OLIVER E. WATTS PE-LS

DATE: August 20, 2020

JOB NO.: 20-5449

CLIENT: Fuel Missions

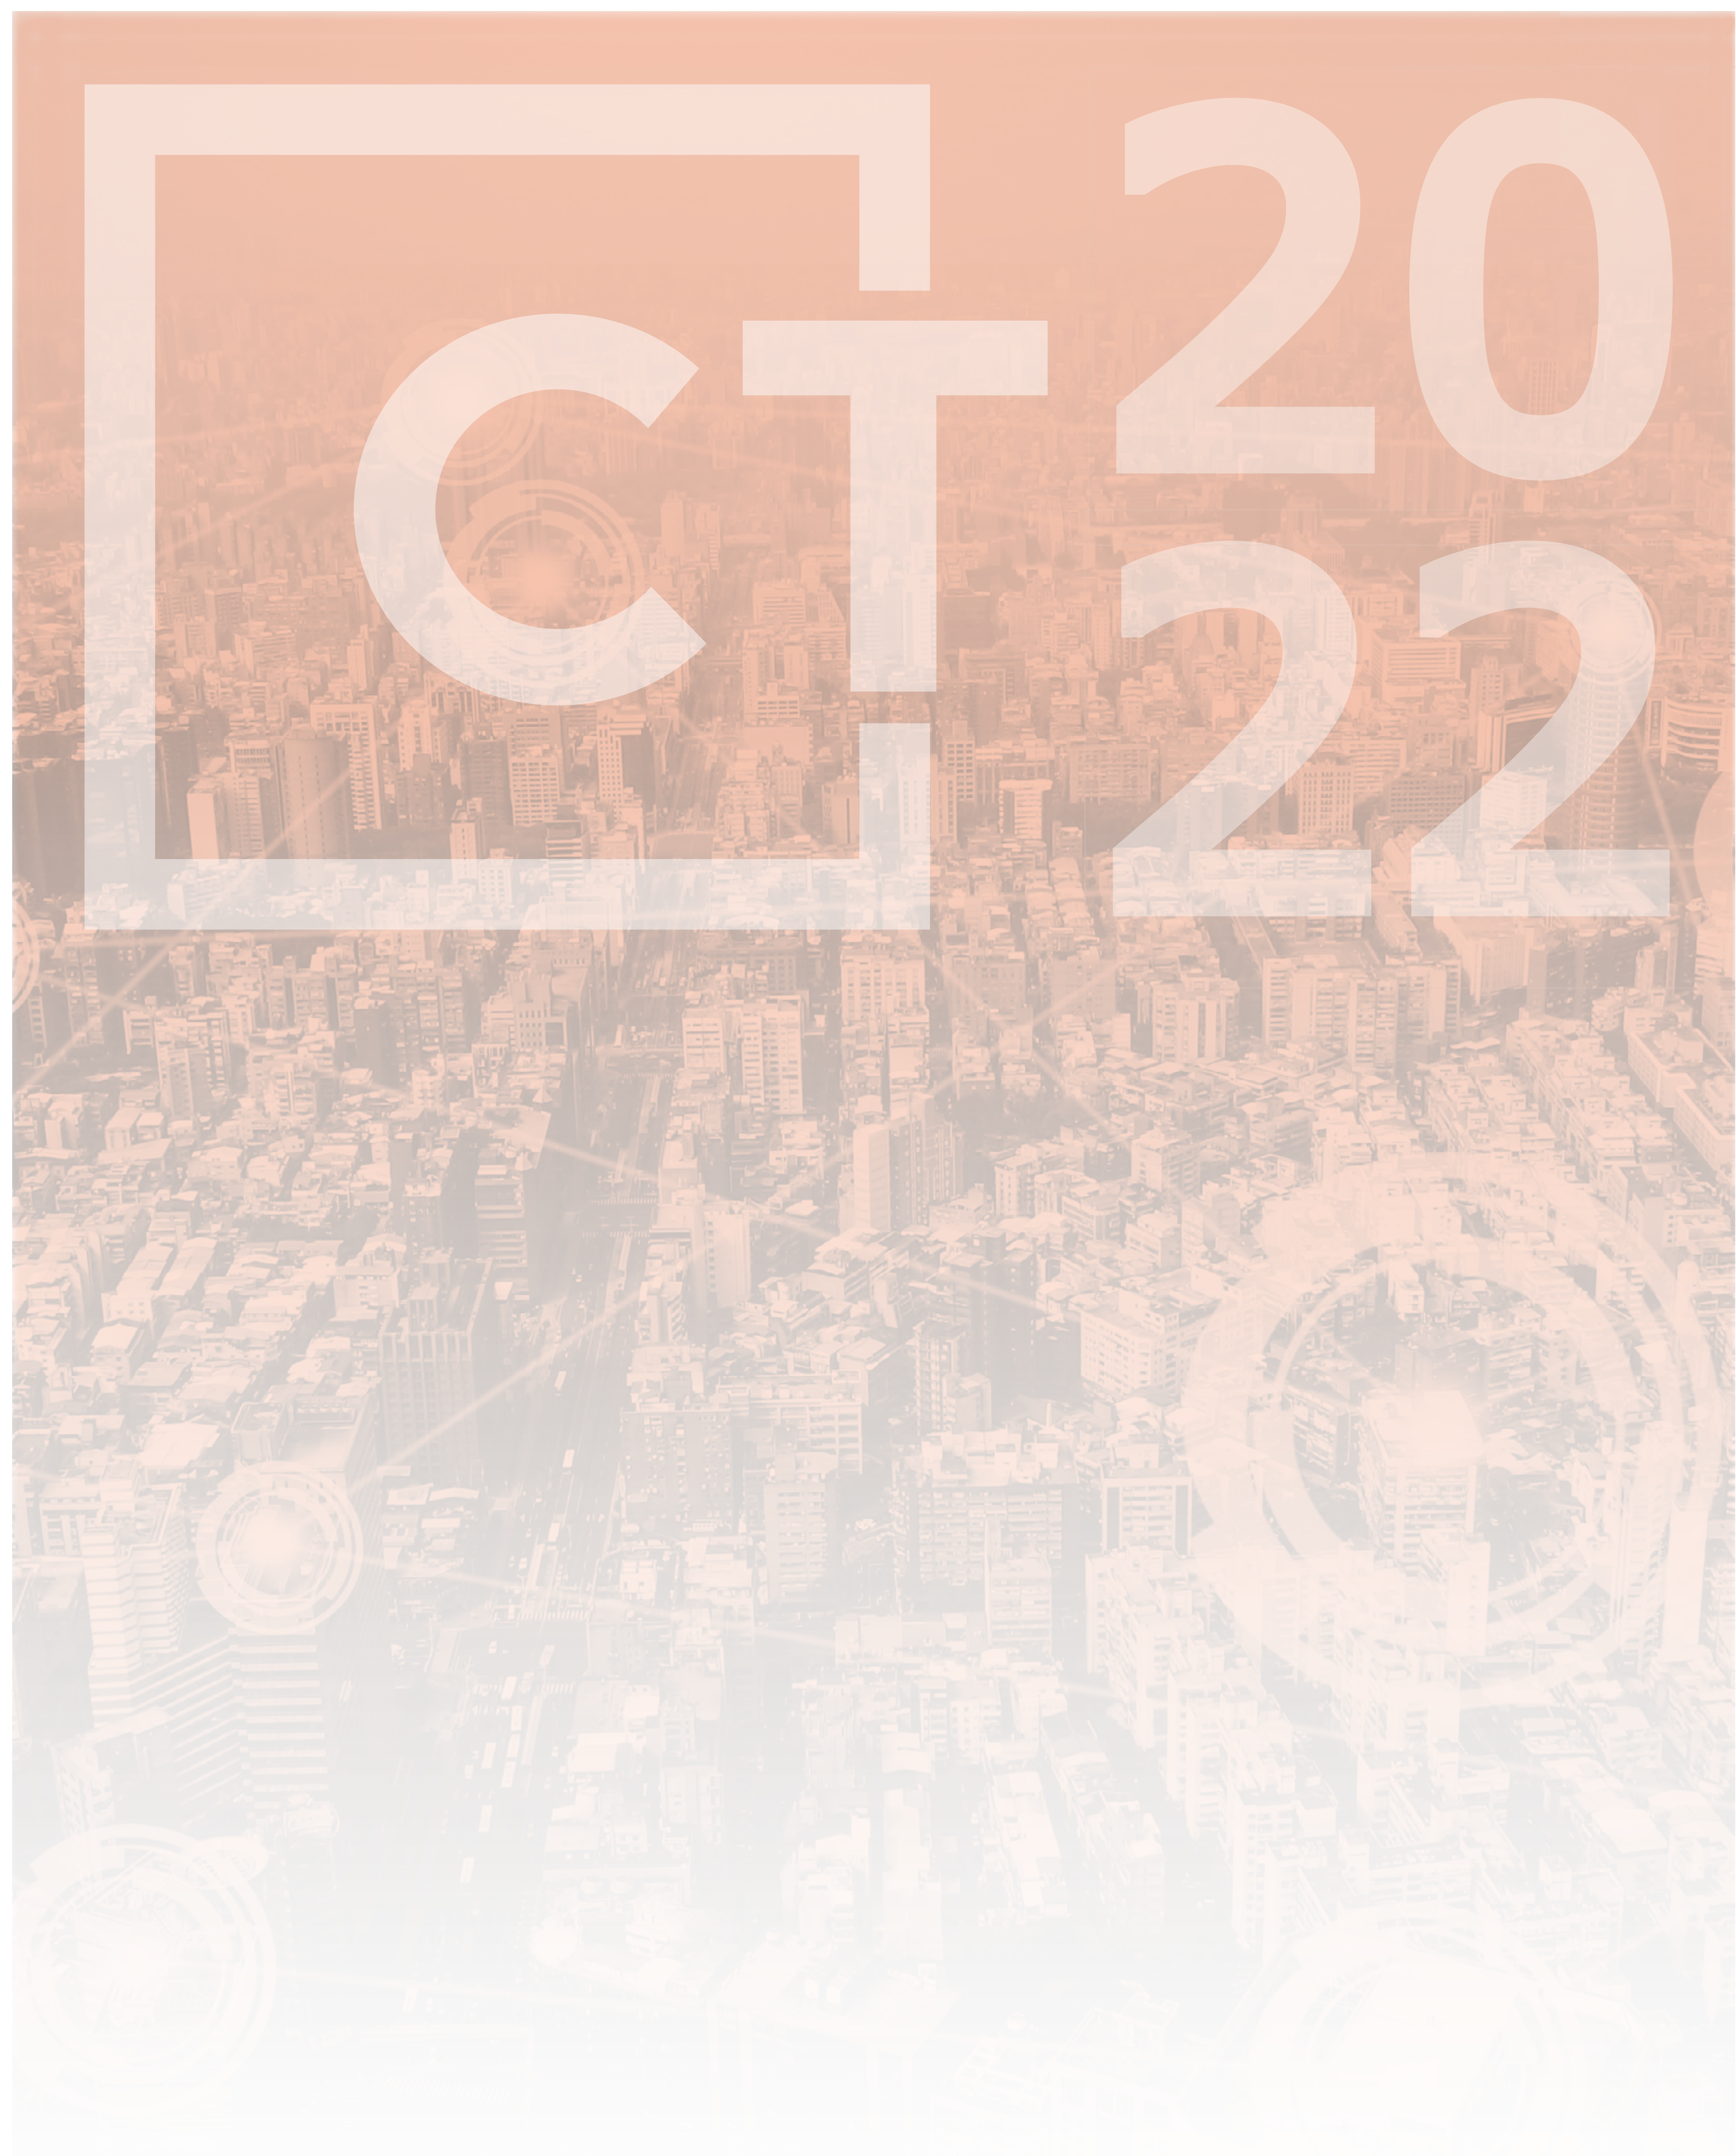
Please note that parking areas with more than 5 parking spaces are required to provide lighting. Please provide us with a photometric plan showing lighting in the critical areas of the site (the area leading from parking area into the building).

There will be NO
exterior lighting
associated with this
project
